DEVELOPMENT PLAN
7-ELEVEN
LOT 1, ACADEMY GATEWAY SUBDIVISION FILING NO. 1
BUILDING ELEVATIONS

PROJECT NO: C7-003
DESIGNED BY: AEG
DRAWN BY: AEG
DATE: 12/04/2017

C5.0
SHEET 10 OF 16

C5.0
SHEET 10 OF 16

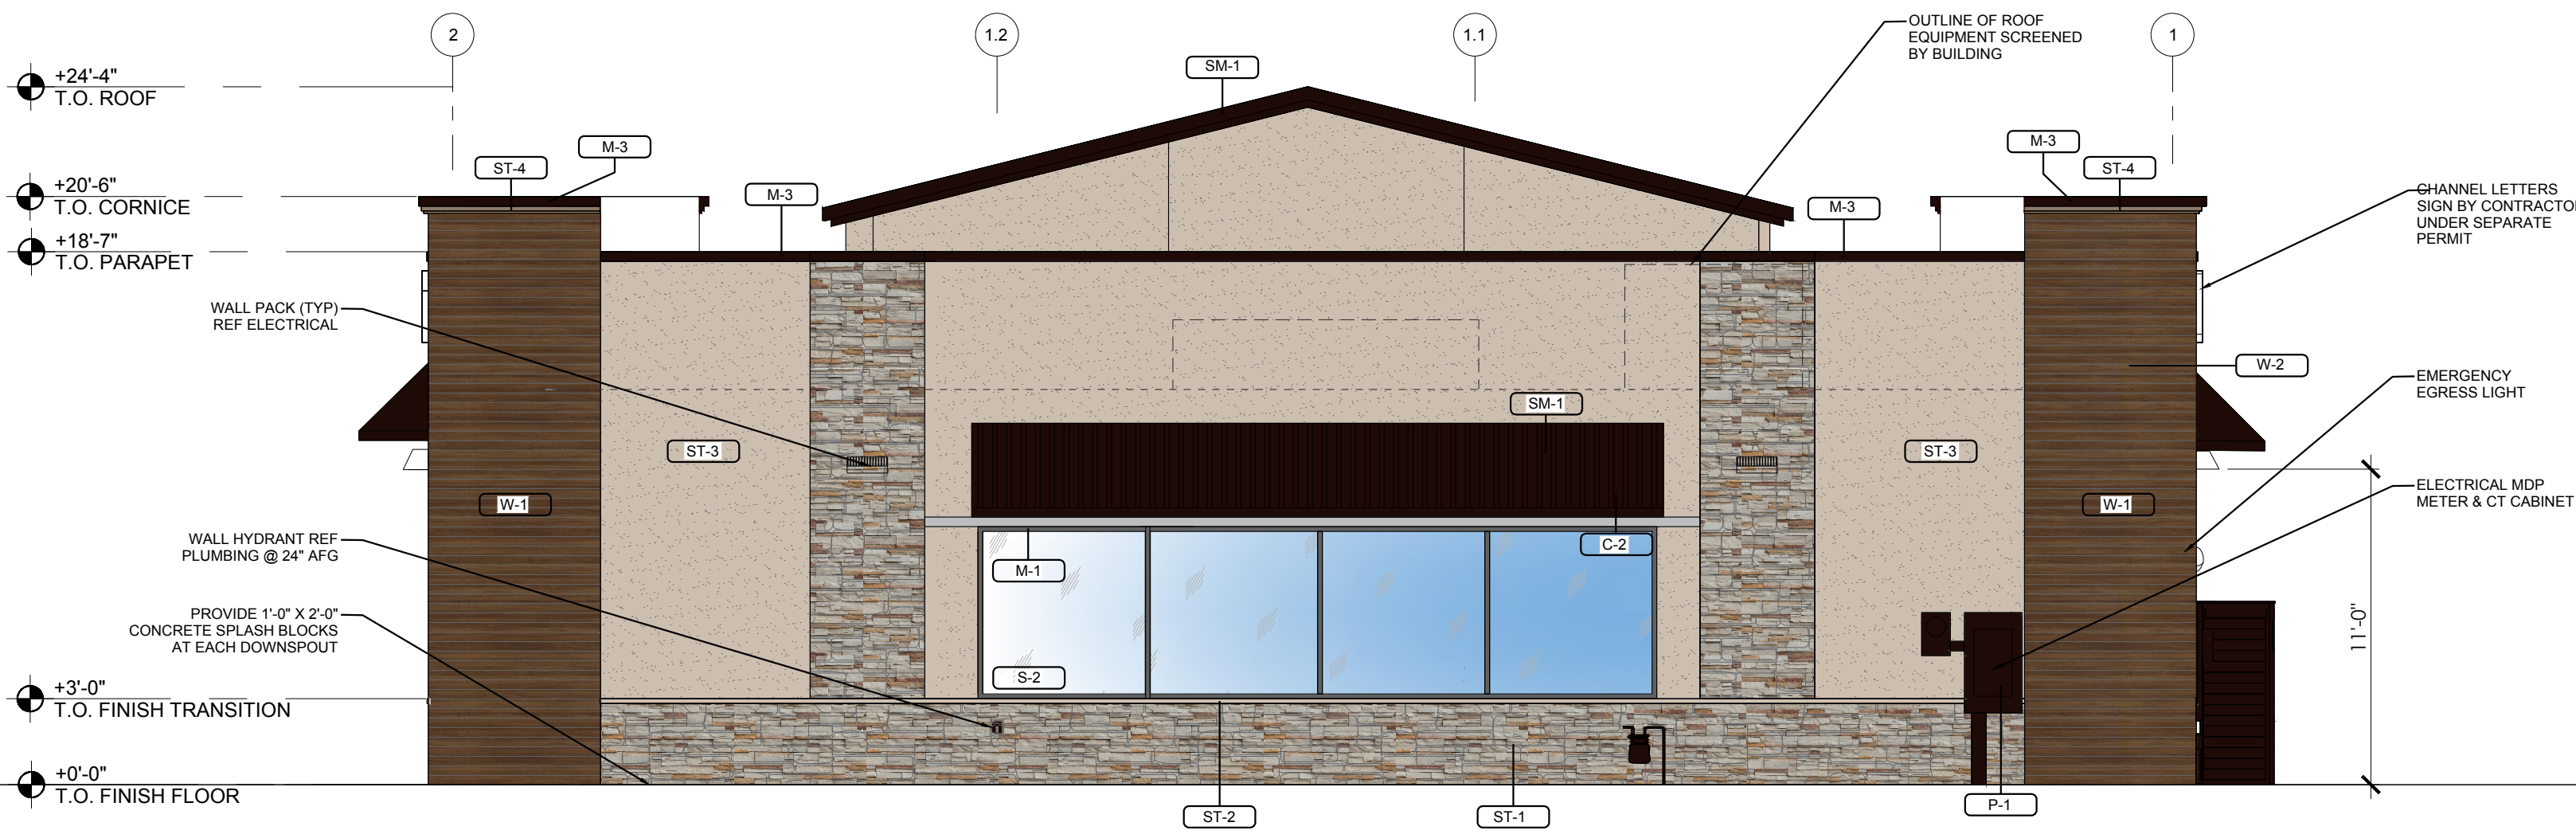
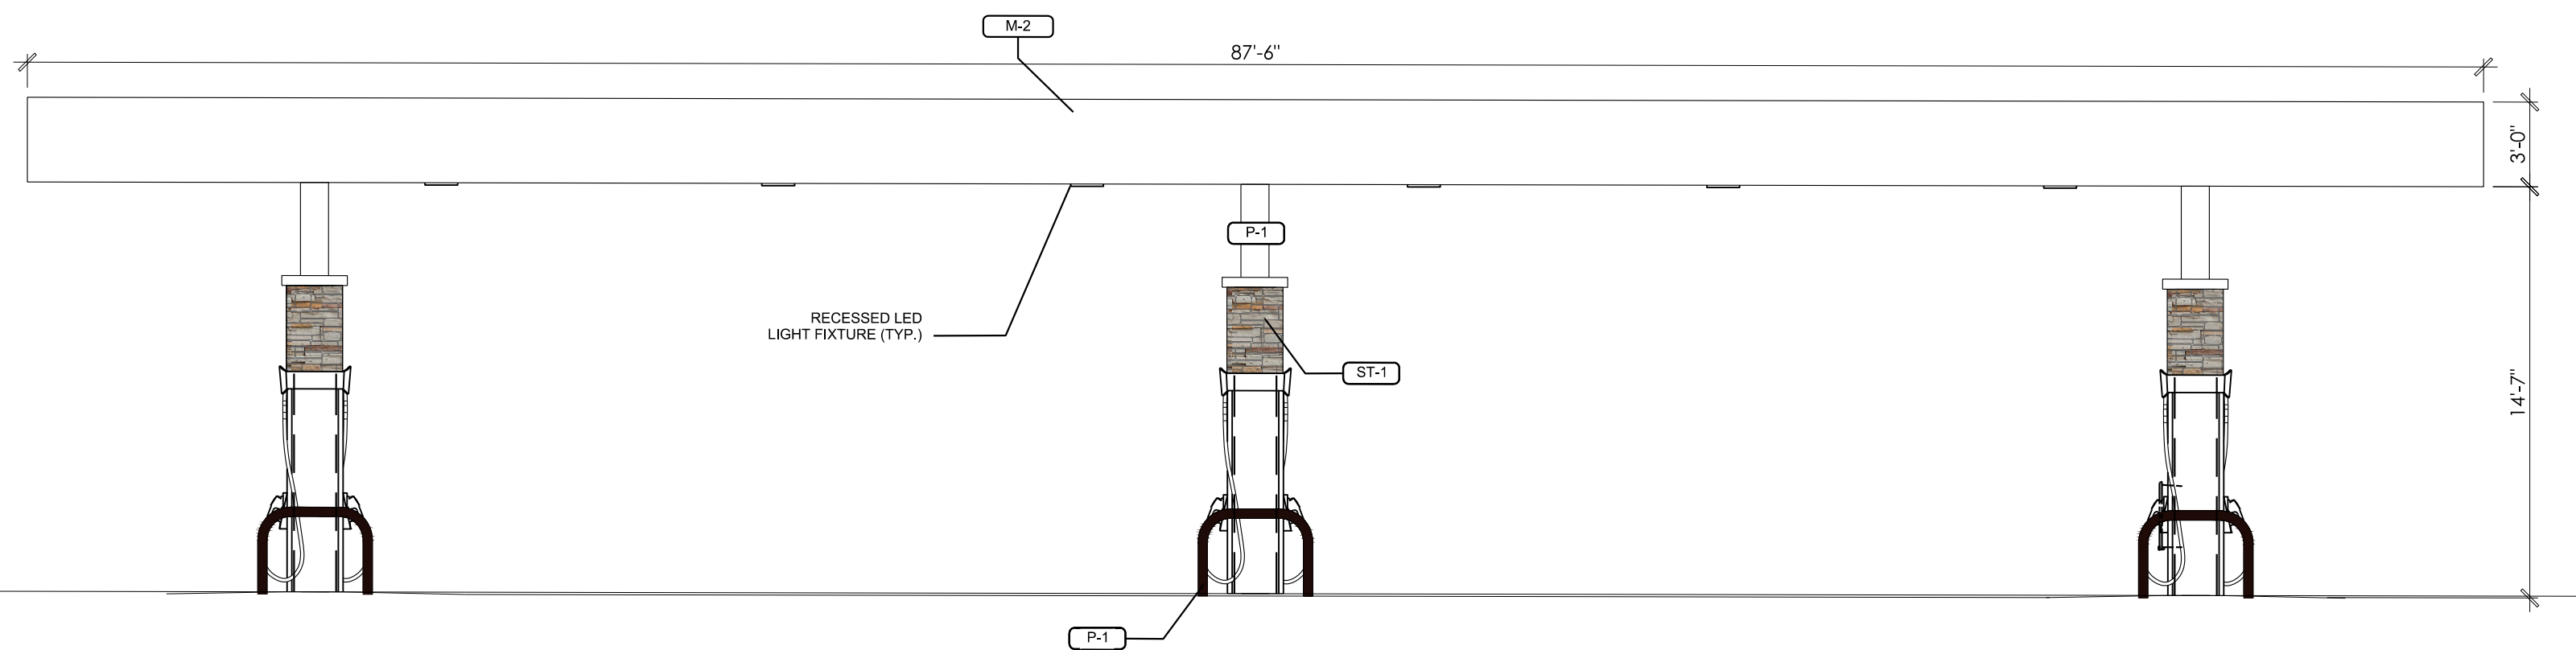
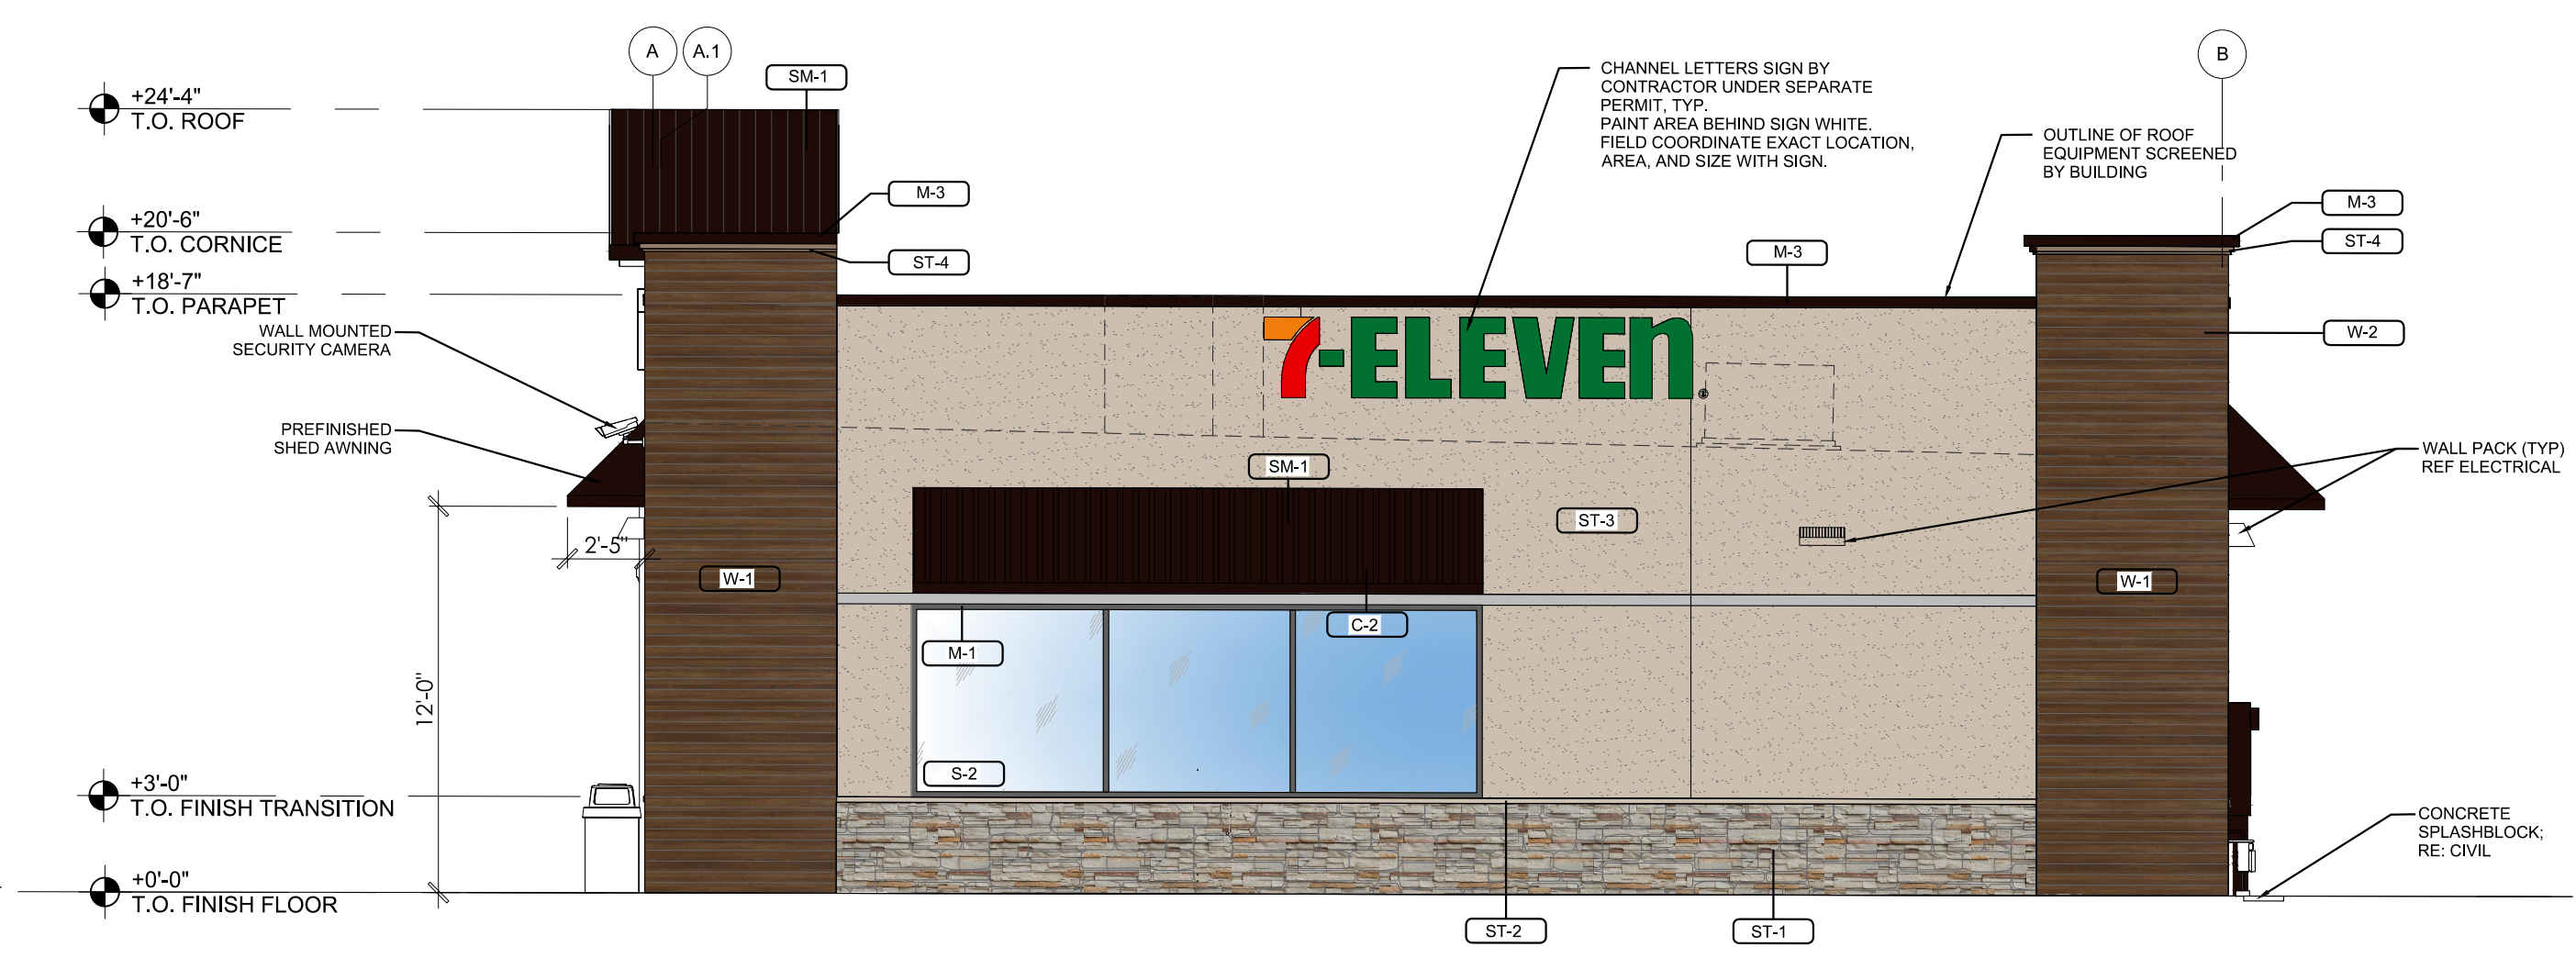
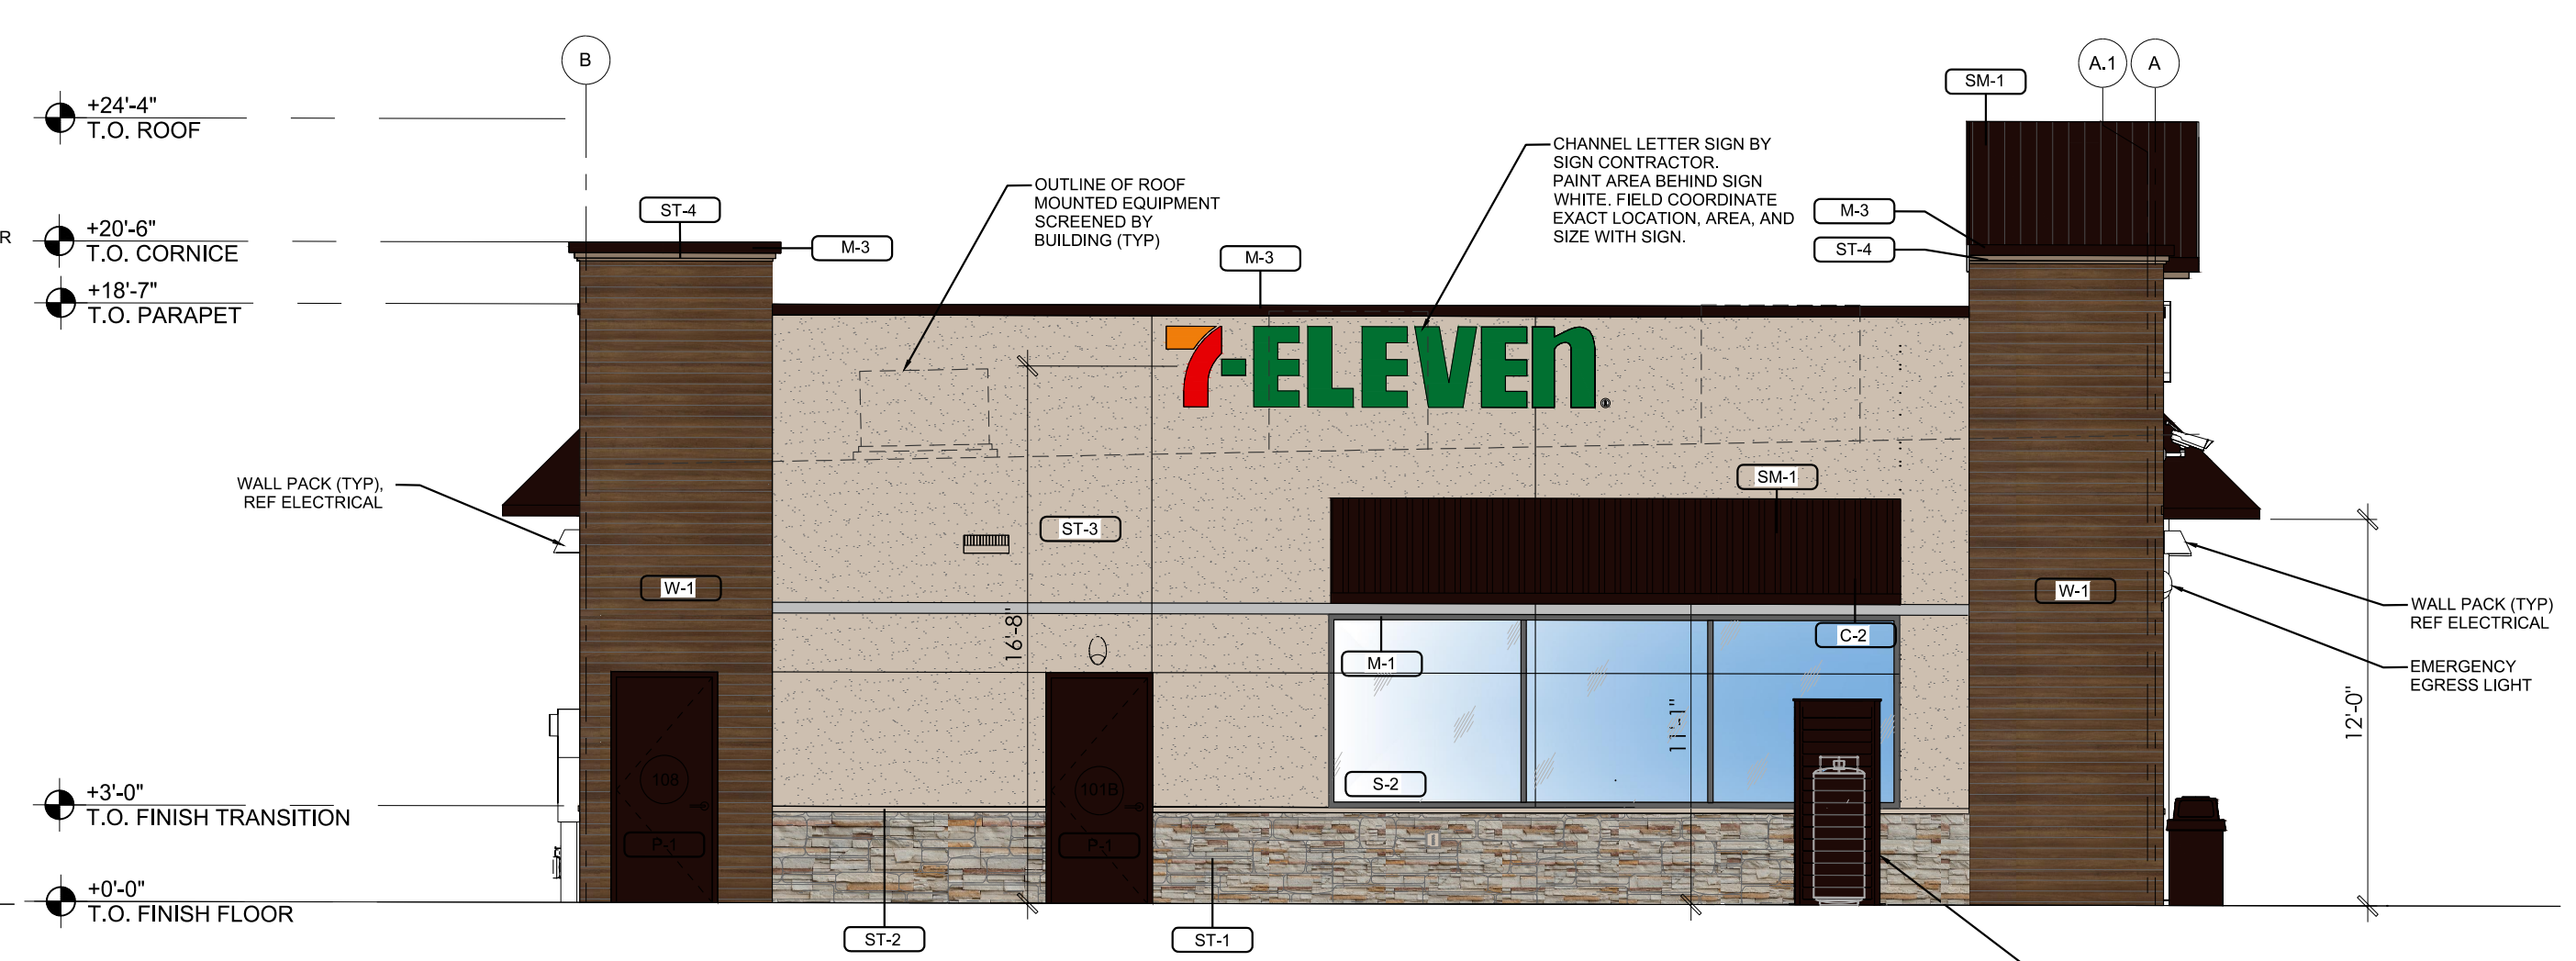
What color and material-metal bronze finish (M-2)? ACM is not on the key.

Stone Veneer is labeled but not depicted. It looks like wood? Which is it?

What color and material-metal bronze finish (M-2)? ACM is not on the key.

Is this stone veneer ST-1?
